GMU: DESIGN REVIEW COMMENTS – APPLICANT RESPONSE

Design review comments for Site 53, 2 Figtree Drive, Sydney Olympic Park – GMU Urban Design & Architecture

SHADOW STUDY

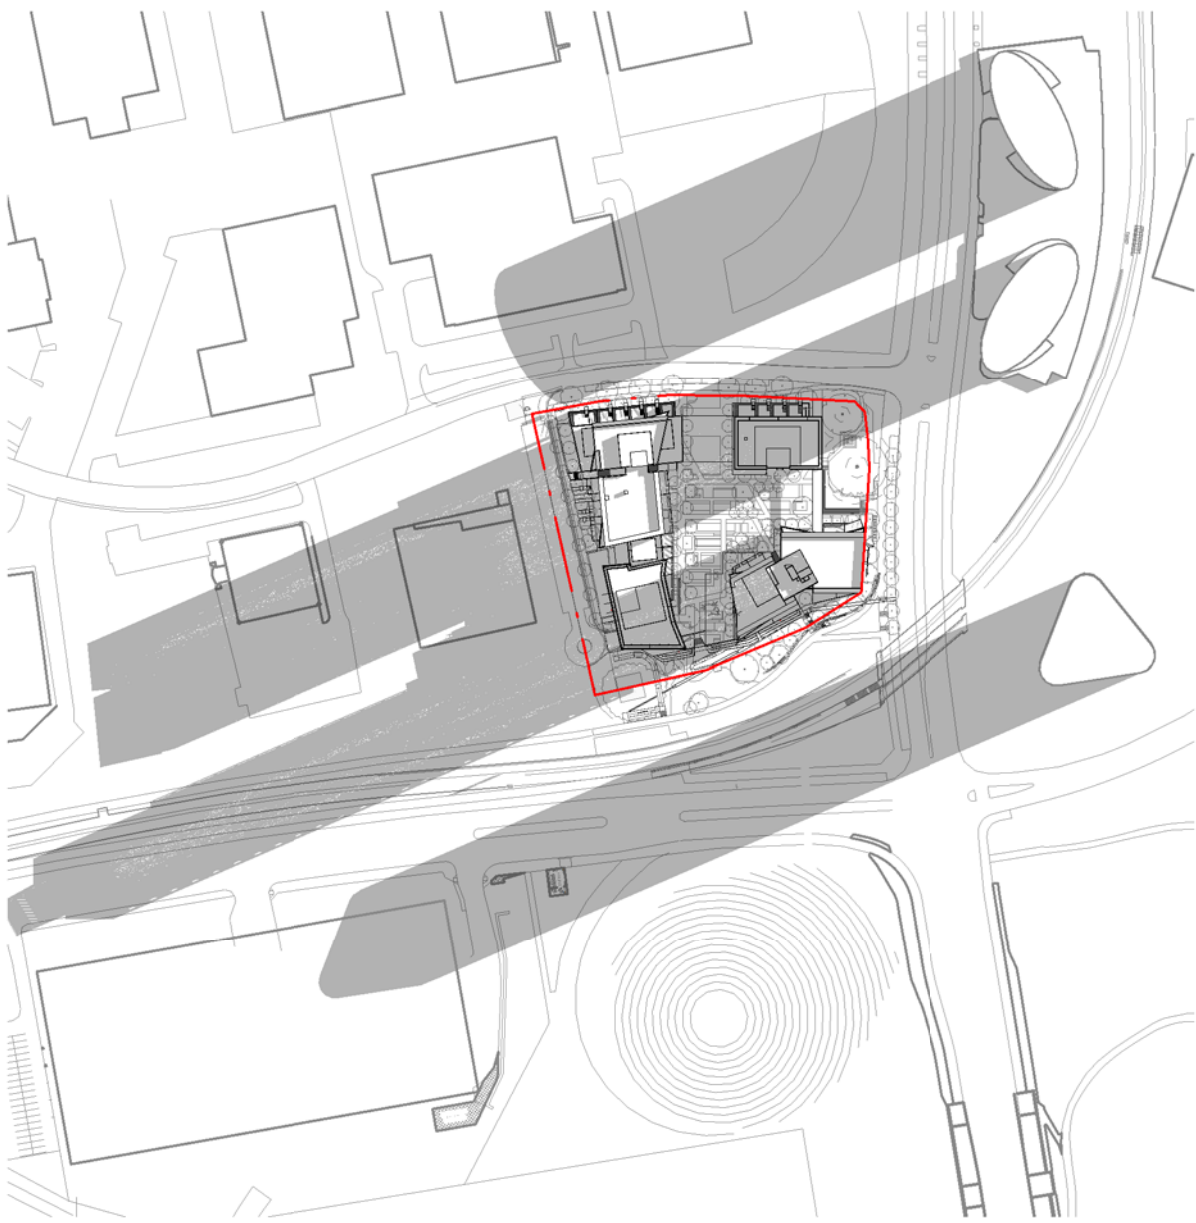
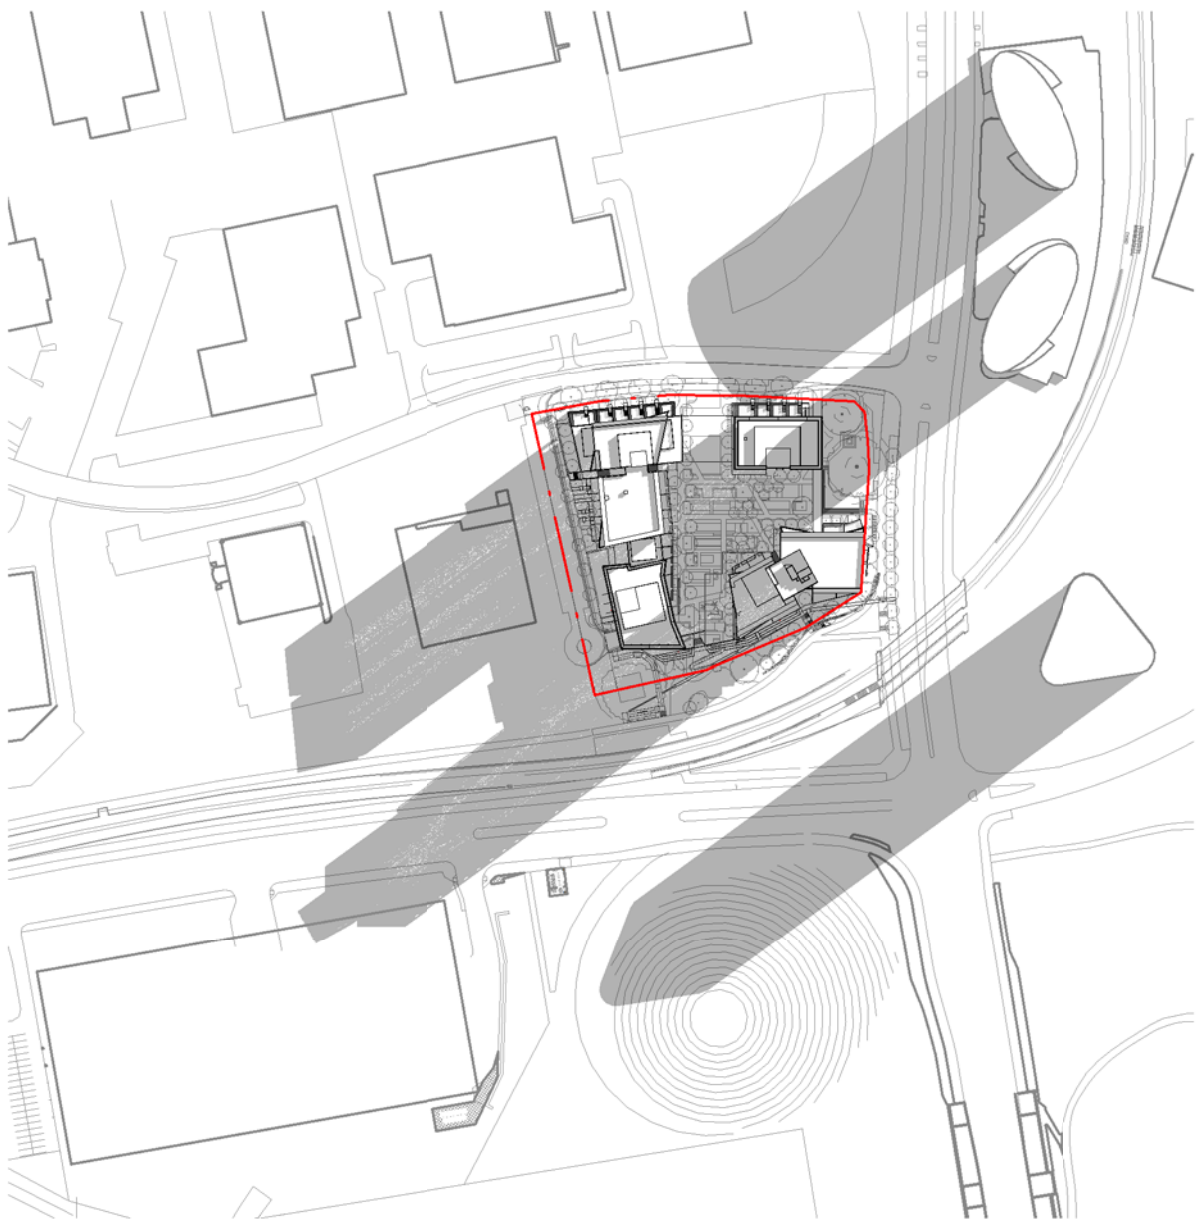
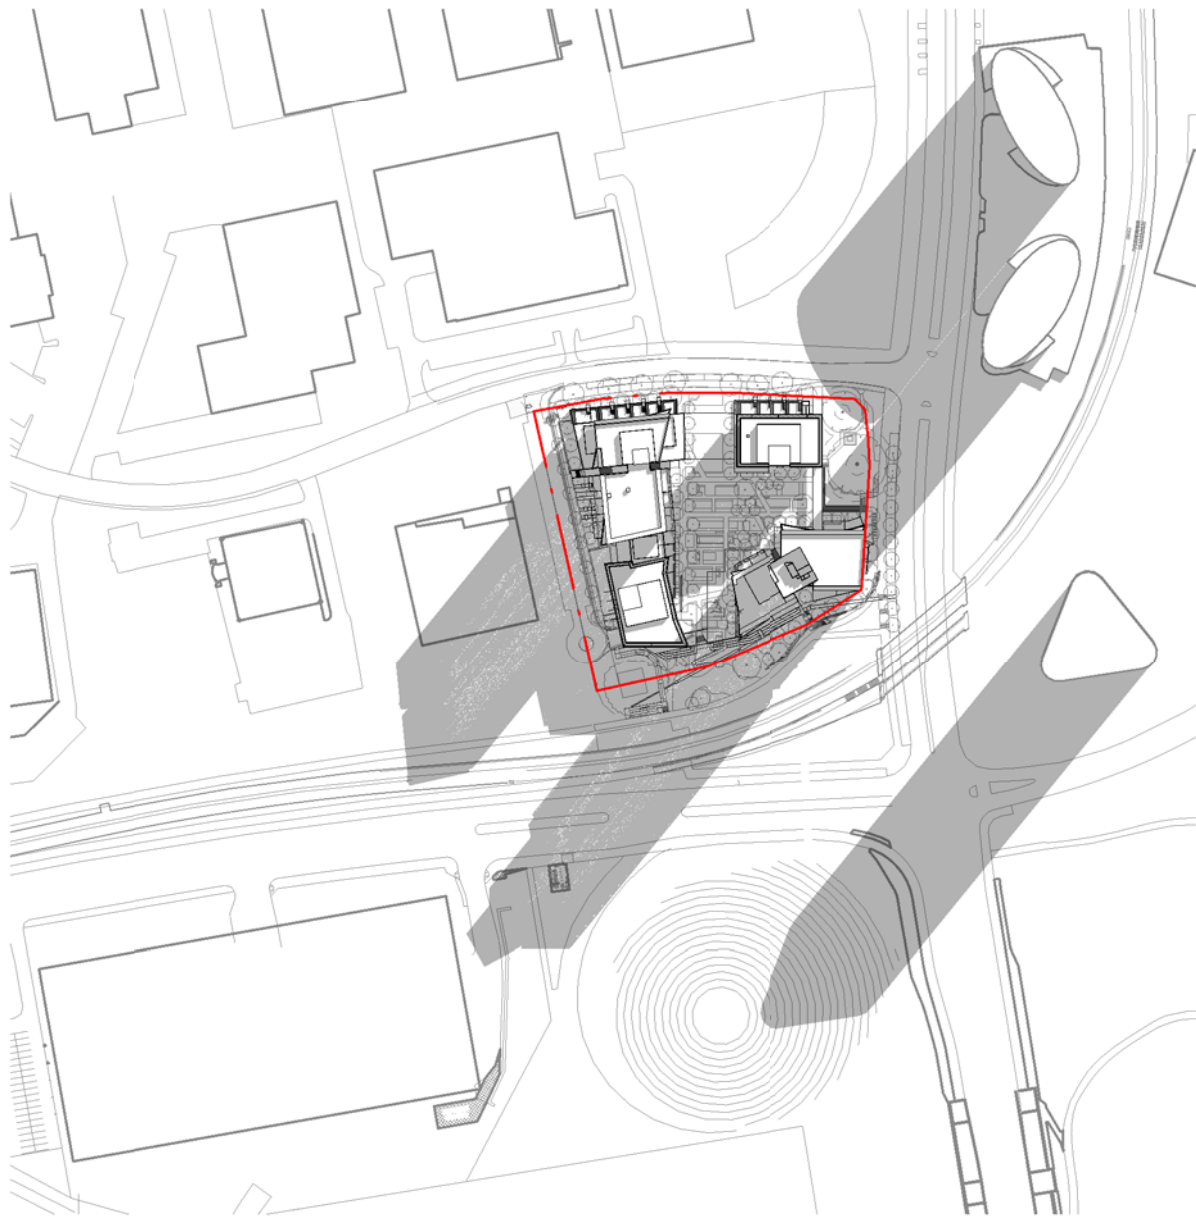
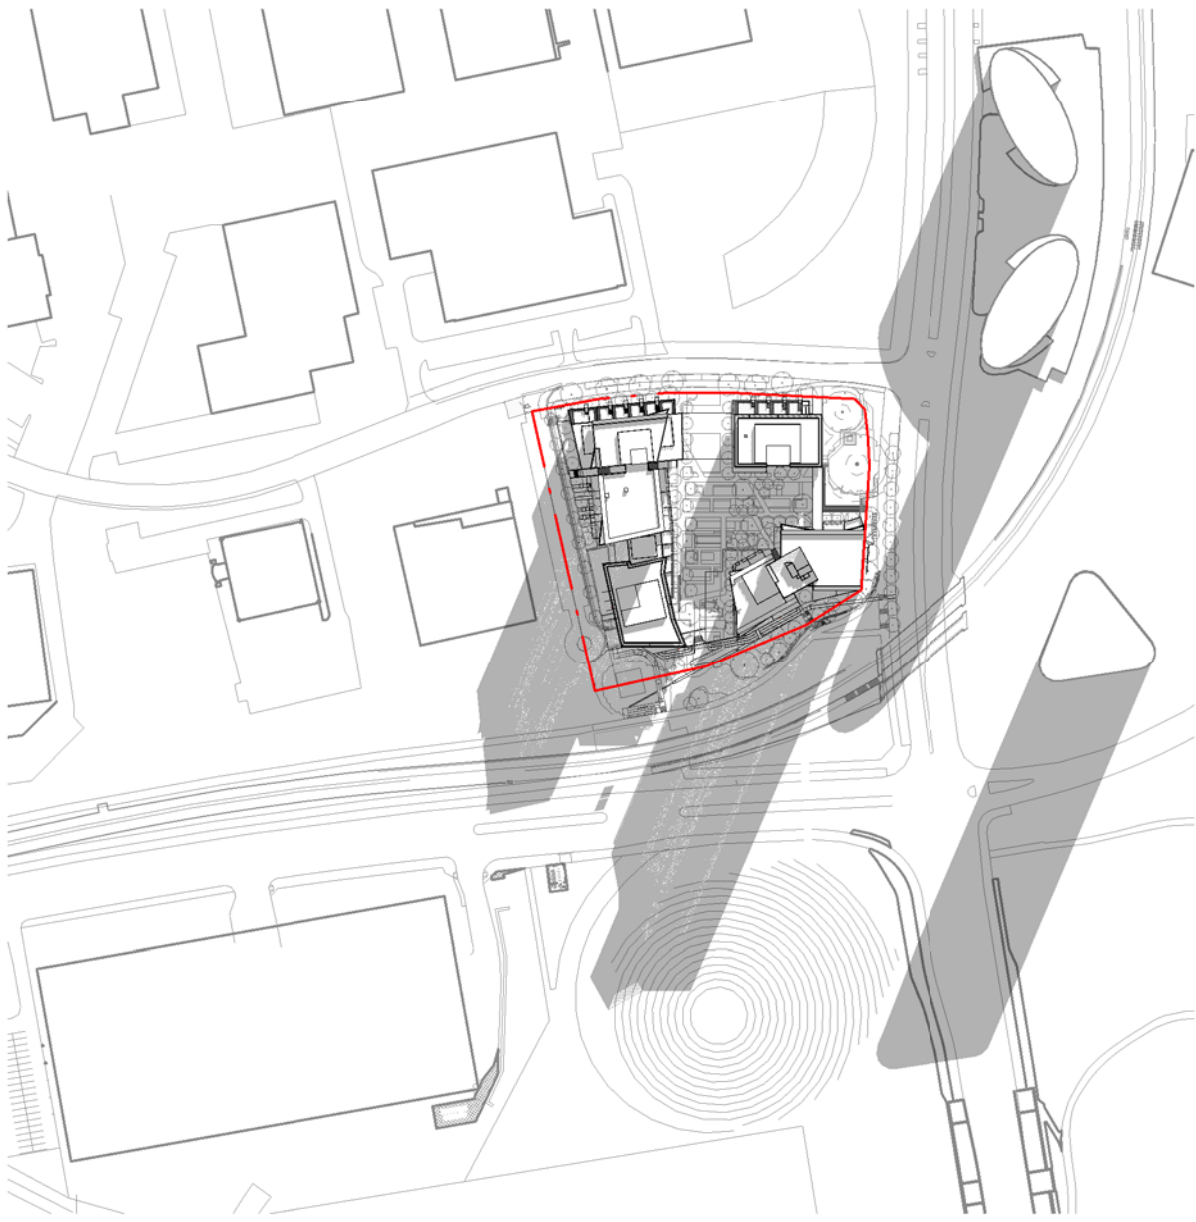
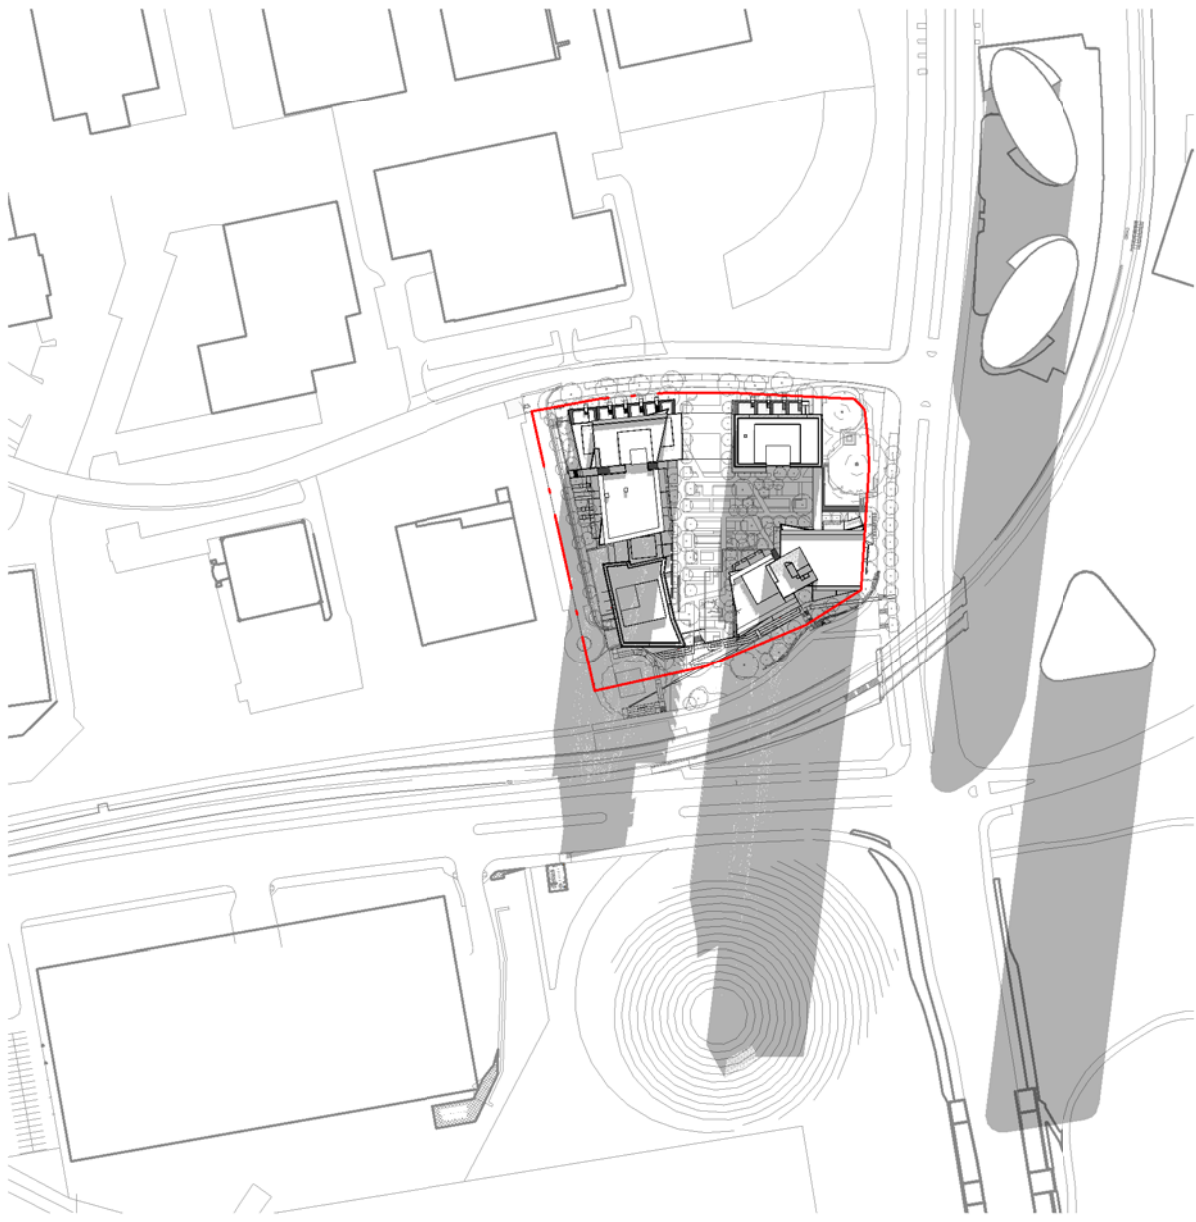
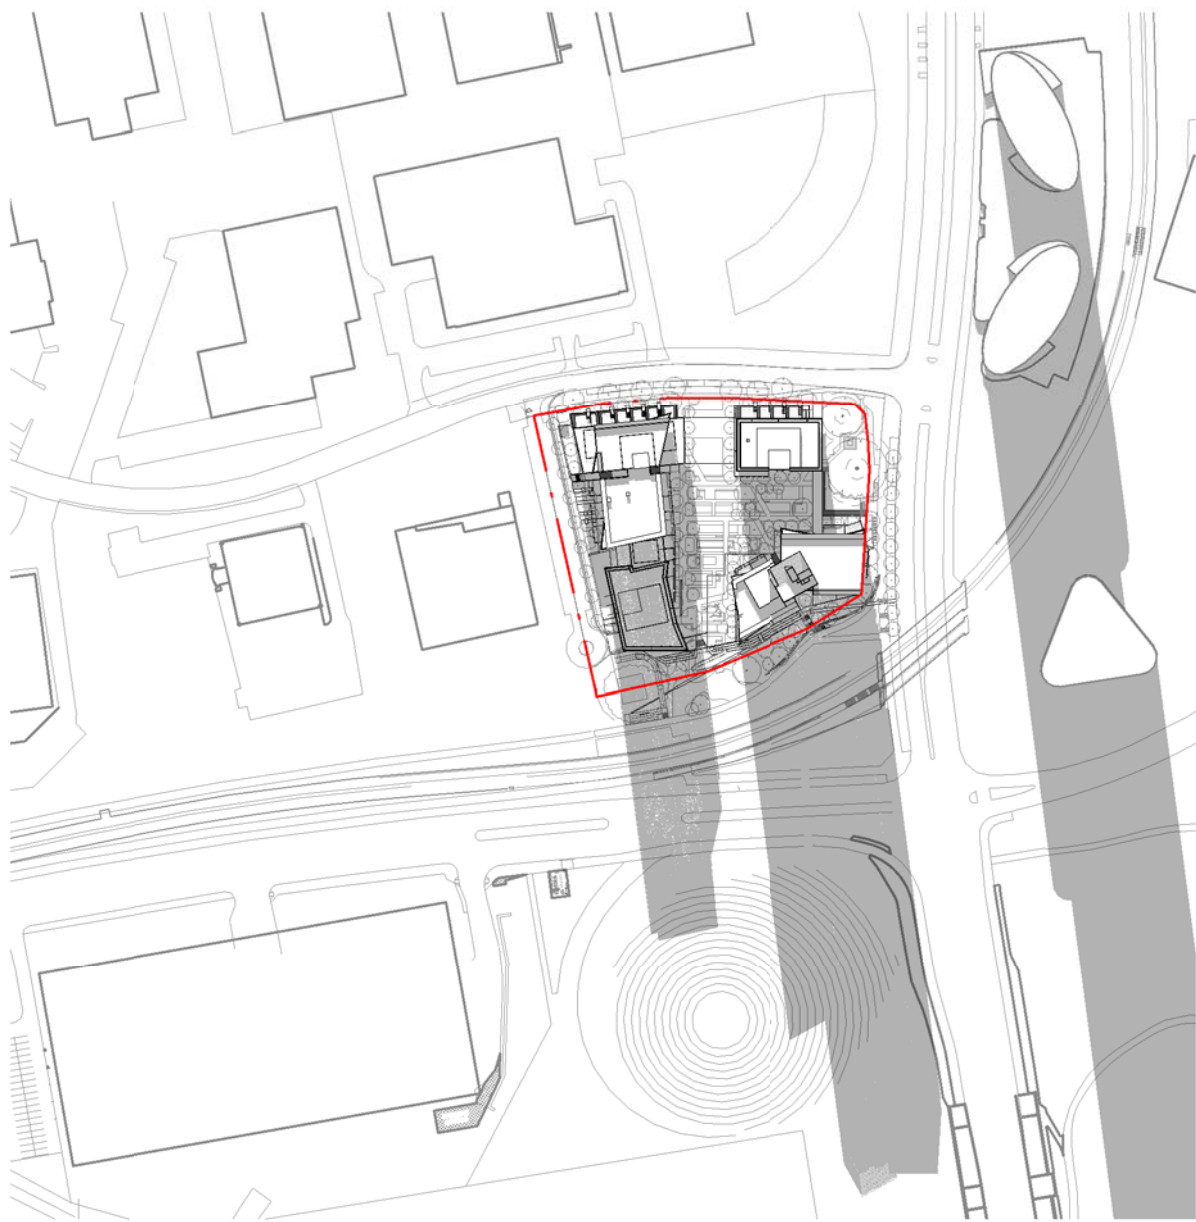
4. DAYLIGHT ACCESS The proposal does not satisfy the ADG's solar requirements. It relies on extended hours (i.e. 8am to 4pm rather than 9am to 3pm) to meet the ADG's minimum solar access requirement and exceeds the maximum percentage (15%) of units with no direct sunlight in mid-winter. The original winning 'alternate scheme' by BVN achieved 74% units receiving 2 hours of daylight between 9am to 3pm and only 6% of south facing single aspect units. In comparison, the quality of the performance of the proposal has declined in the current scheme. The use of extended hours might be reasonable if the context included significant impact from existing adjacent towers. However, as the site is not impacted to a meaningful degree by surrounding buildings, we do not consider the reliance on extended hours to be justified. Given that the site has a generous site area, frontages and a reasonable level of flexibility for configuration, the design should be able to achieve the ADG's requirements fully.	See discussion at Section 4.3.1 of the Report.
